From: Geoff Baxter
Sent: 24 February
To: Amber Willard
Cc: Cllr. Hugh Co
Subject: AW/3/21/HH

PROPOSED FIRST FLOOR

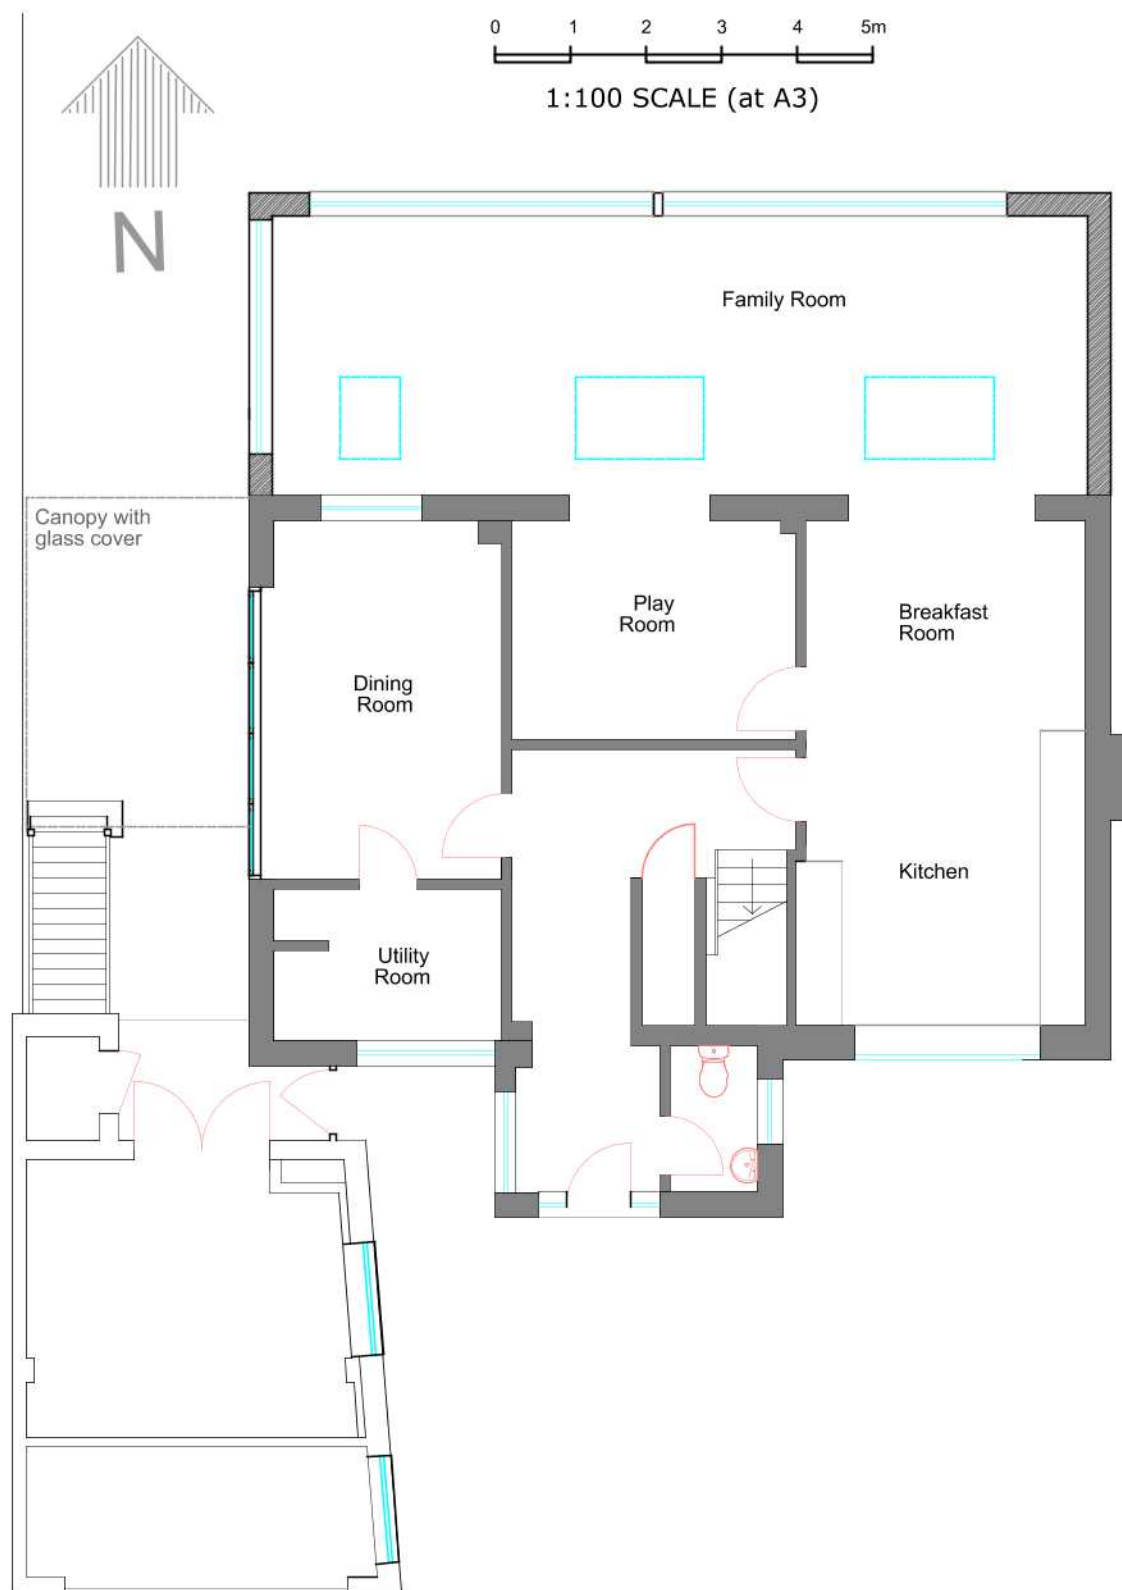
One other area of concern is the reconfiguration of first floor rear facing rooms. I am aware that internal changes normally fall outside of planning criteria, however in this case these changes form part of the overall planning submission for this property. Our concern is that a further first floor window will be created on the rear as part of these changes. This will be as a result in two bathrooms being created.

While we have no objection to their use, we hope you share our view that a 'condition' of these two rooms is that glazing should also be obscure, which is generally the norm for such rooms. I state this as the existing bathroom glazing is not obscure and if therefore could be a problem. If this is permitted as part of this application.

Drawing No. C.1062H - 04 Date: 22-12-20

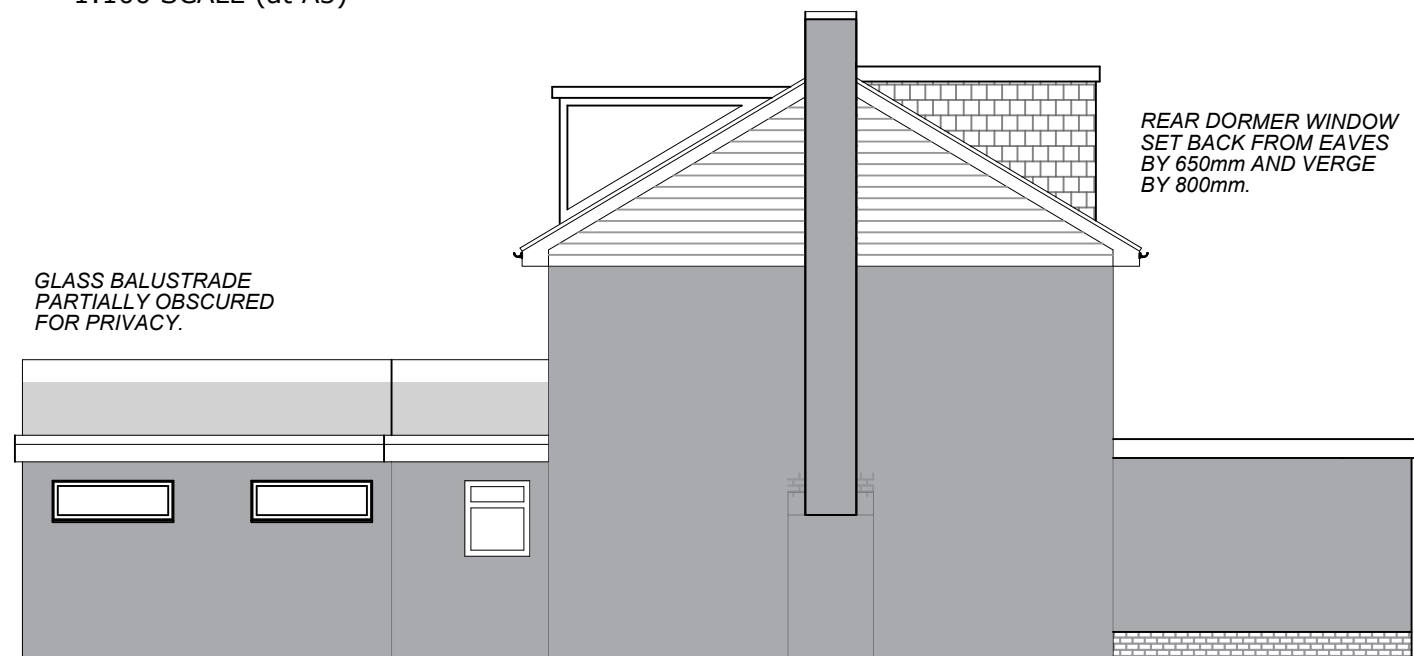
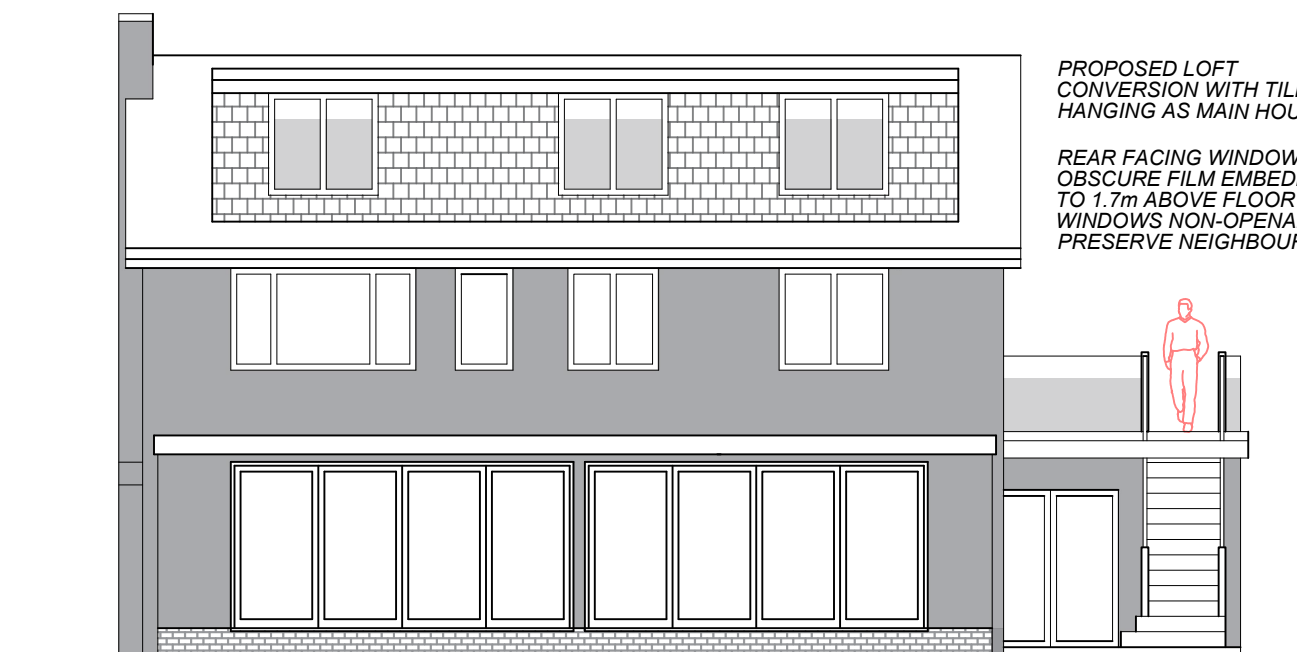
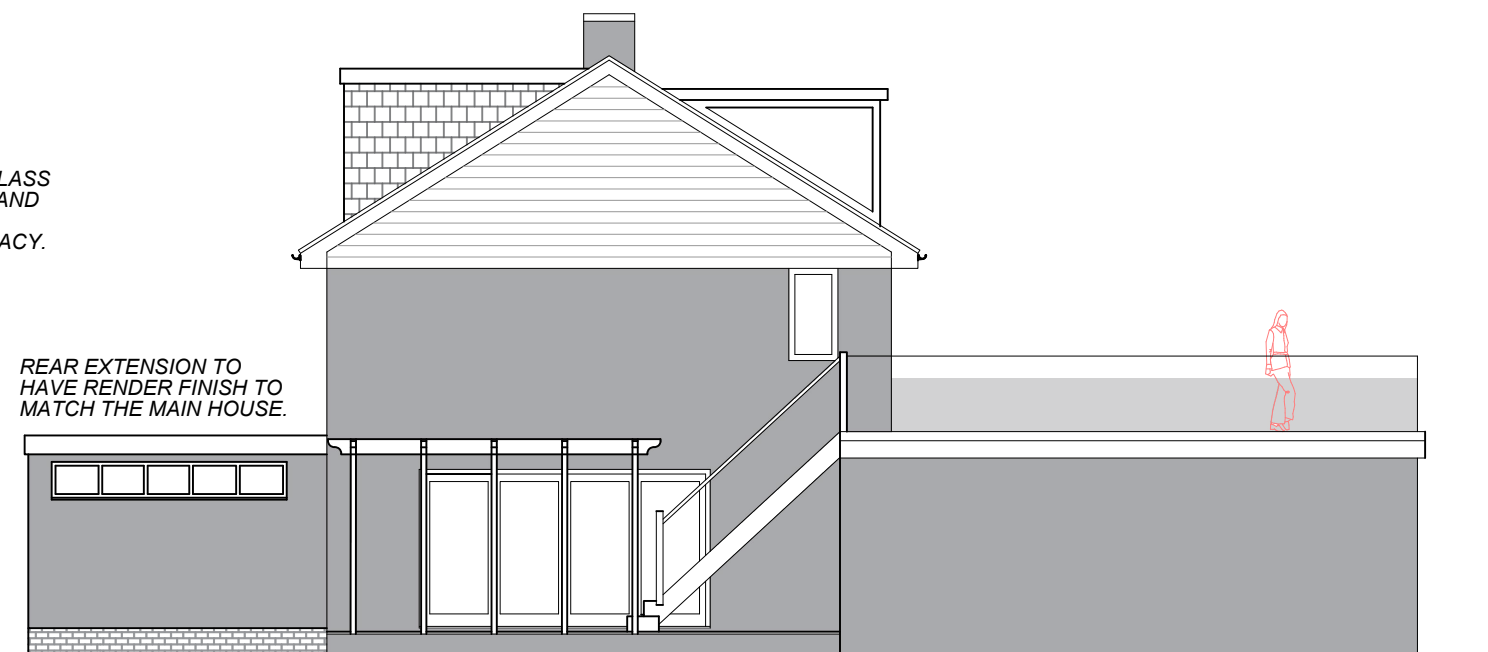
Firstly it is stated in the Architects planning statement and drawings that obscure glazing will be used to a height of 1.7m from floor level. In normal situations this may be acceptable to provide screening, however in this case it is felt that is not the case. It will be essential to lower floor levels in order to create sufficient height in the loft conversion due to the particularly shallow roof pitch. The consequence of this would result in the proposed distance of 1.7m being measured from a much lower floor level. This would result in a much smaller area of glazing being obscured, thereby not providing the level of screening expected. In order for there to be no misinterpretation it is essential that 'all' glazing on this level needs to be fully obscure. Alternatively the area of glazed screening needs to be measured from the window base, and not as proposed the floor level for the reasons stated.
